## City of Albuquerque

April 26, 1979

RE: PUTT PUTT DEVELOPMENT

PUTT-PUTT
DRAINAGE & GRADING PLAN

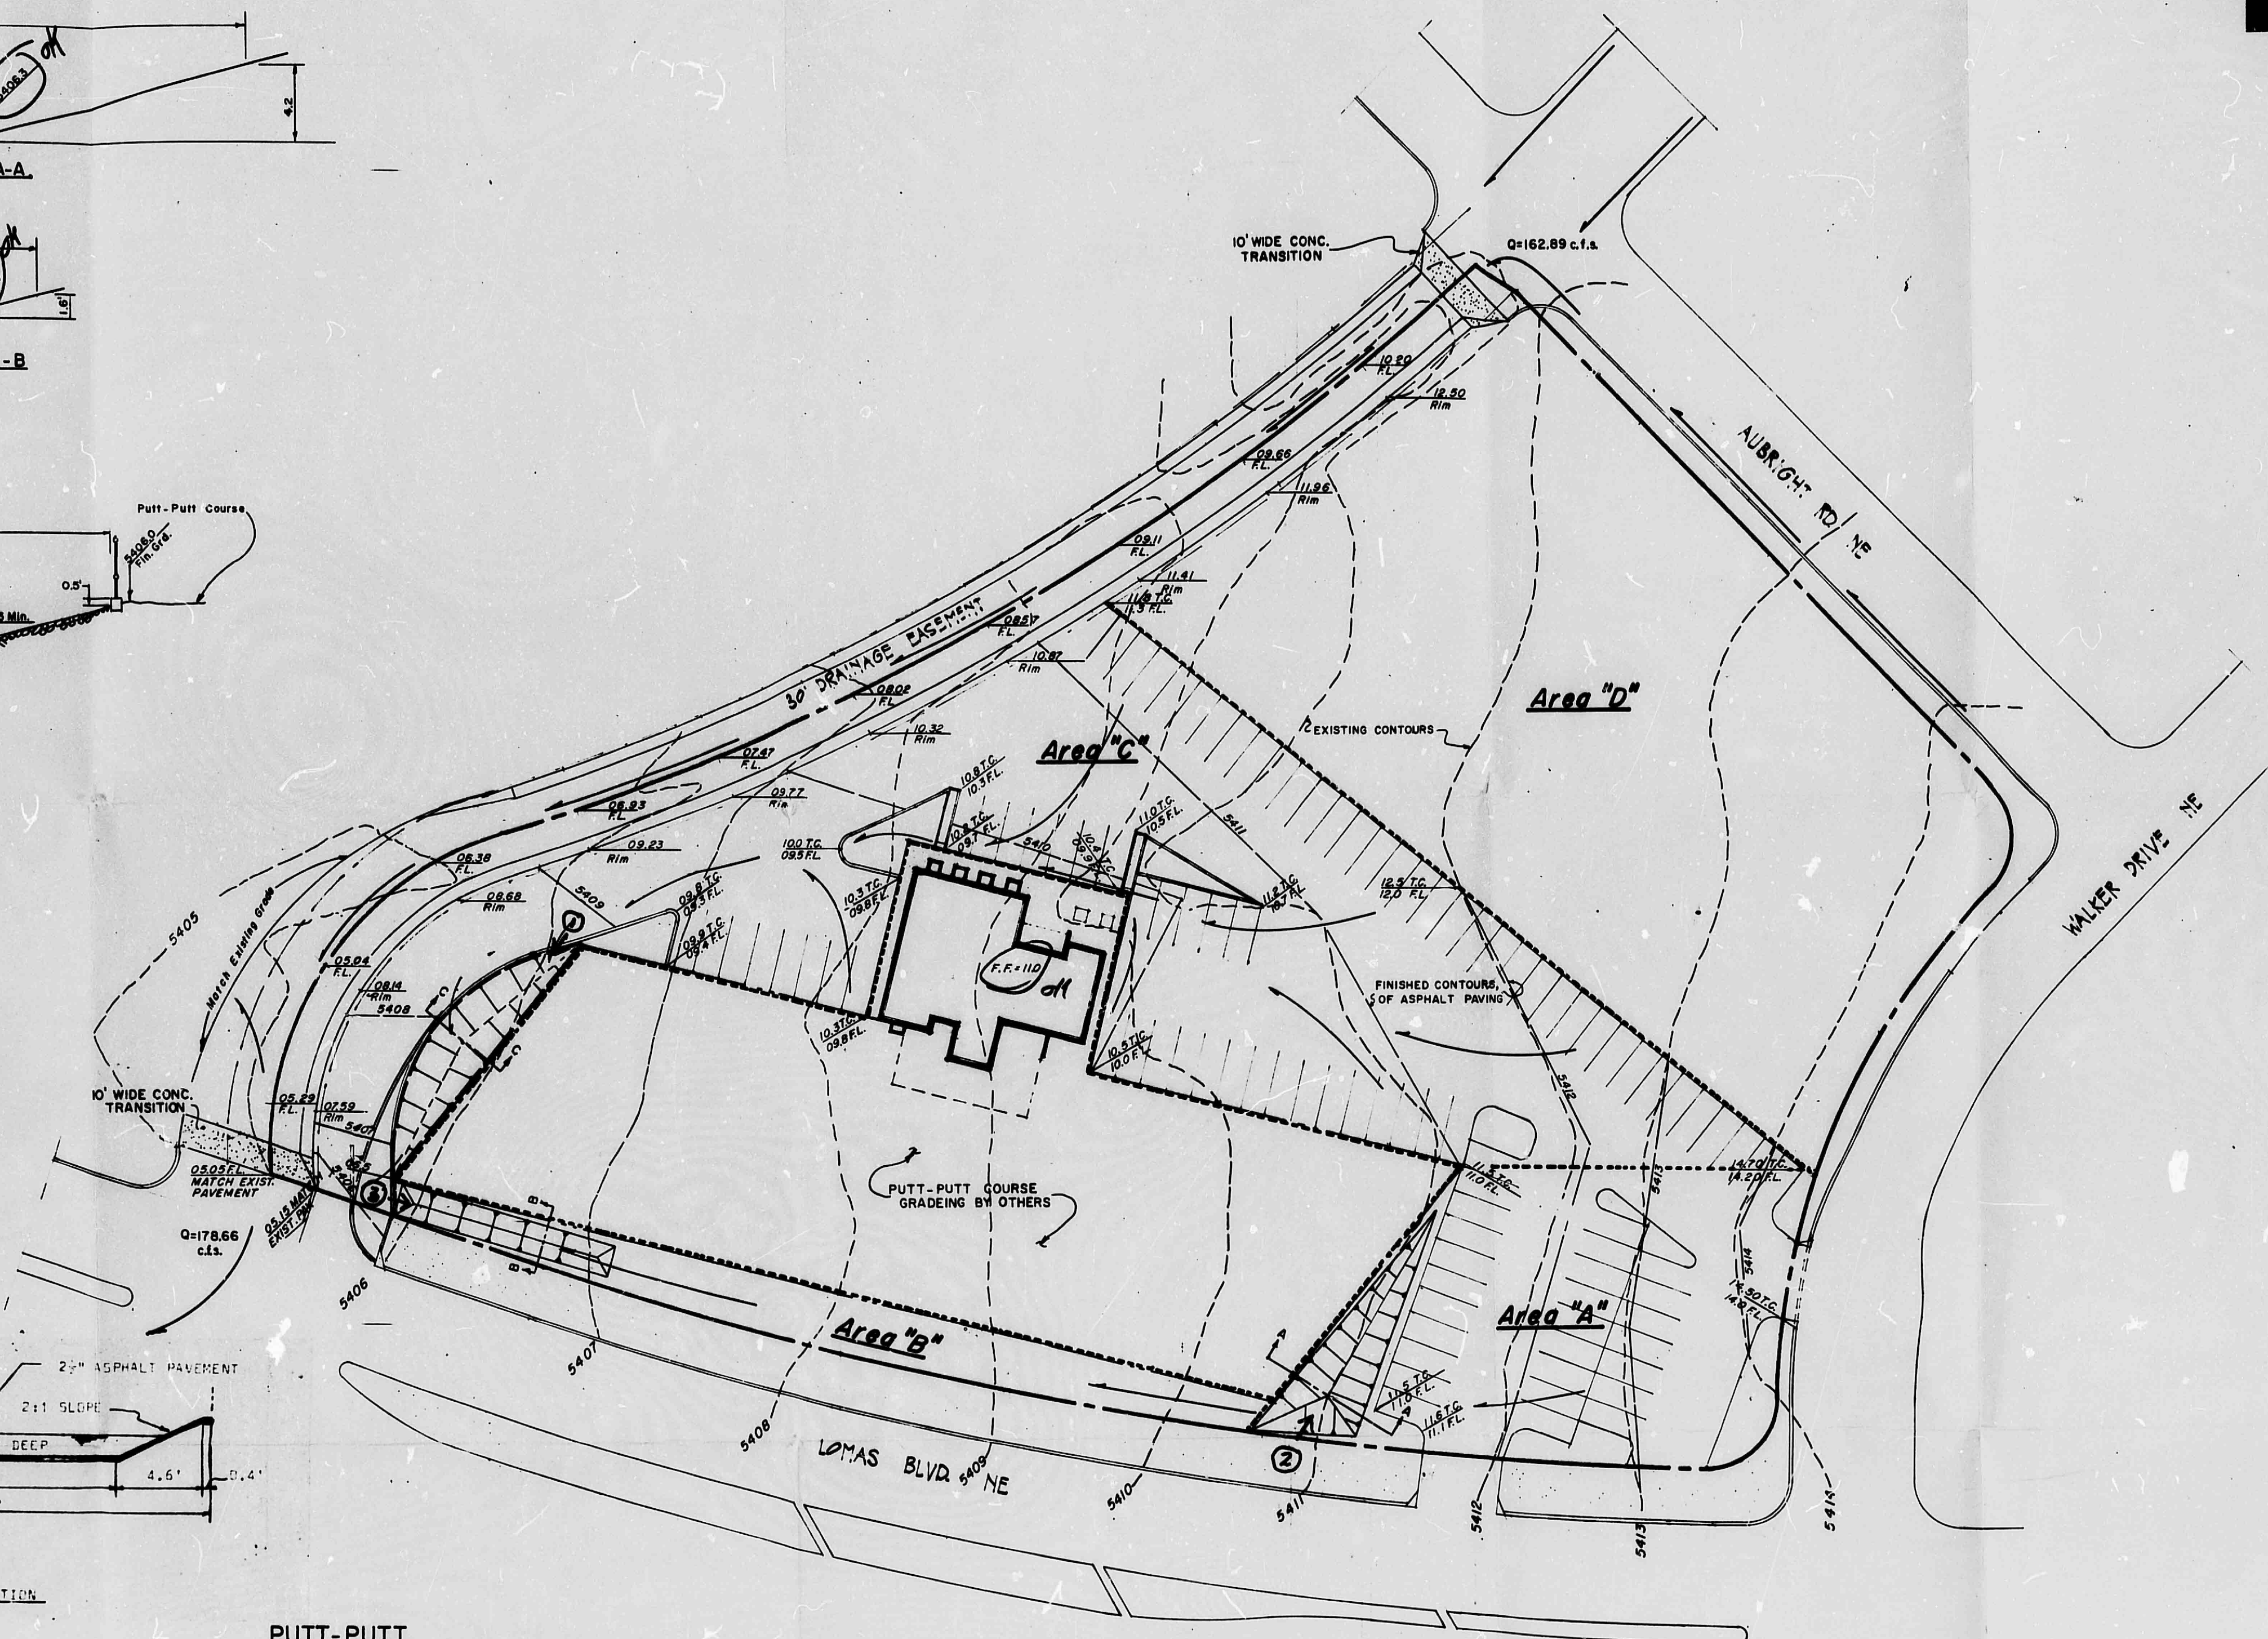
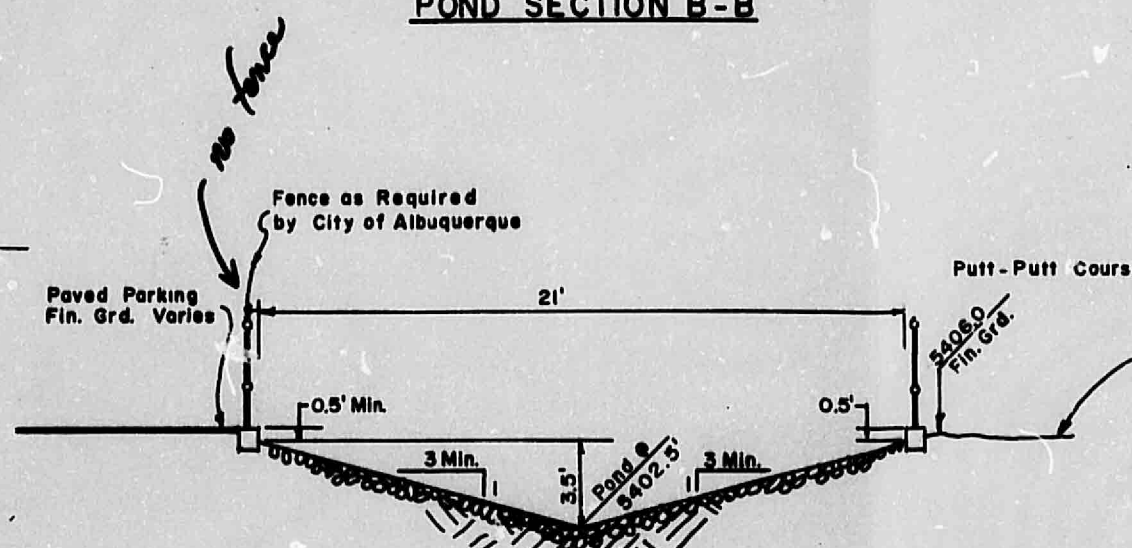
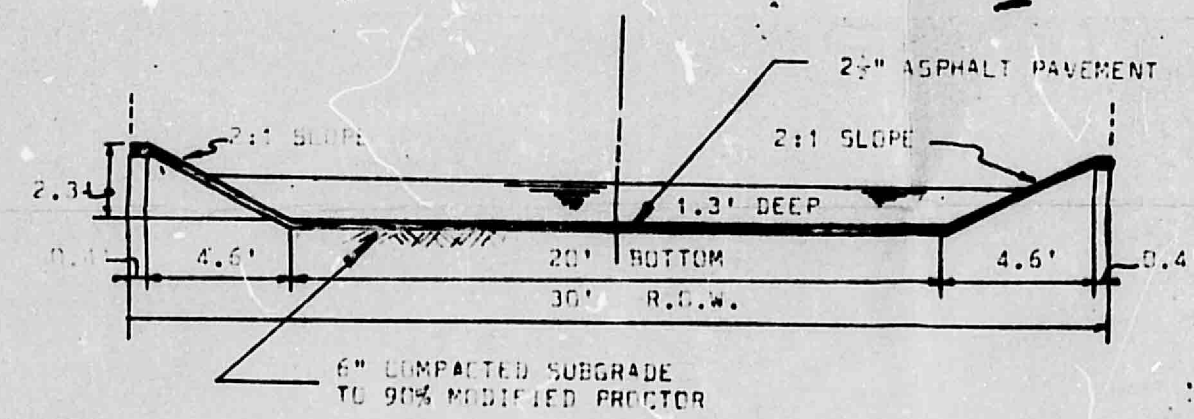
This letter is written to amend previous correspondence in regard to the caption development. The requirement that no increase in run-off will result as a consequence of this development is reiterated. Ponding provisions on site must be made in order to comply with this requirement.

In regard to the construction of the drainage facility, at of the Northwest boundry of the property, within the existing 30 ft. drainage easement, after discussions with Mr. Rip Orr and Mr. John Myers, the conclusion was reached that the development of this project will be granted if the developers construct the asphalt lined channel, indicated in the drainage report, from Aubright Street to the location where the water is currently discharging.

The main concern is to insure that no change in the location of this charge of the surface flow be made at this time and that no direct discharge onto Lomas Blvd. results from this development. At a future date, as the City funds become available, provisions will be made for the comprehensive solution of this problem.

The asphalt channel side has been lowered on the west side as shown on the drainage plan to permit the runoff to flow into the low spot on the undeveloped tract of land to the west before flowing across Lomas Blvd. This maintains the existing runoff pattern.
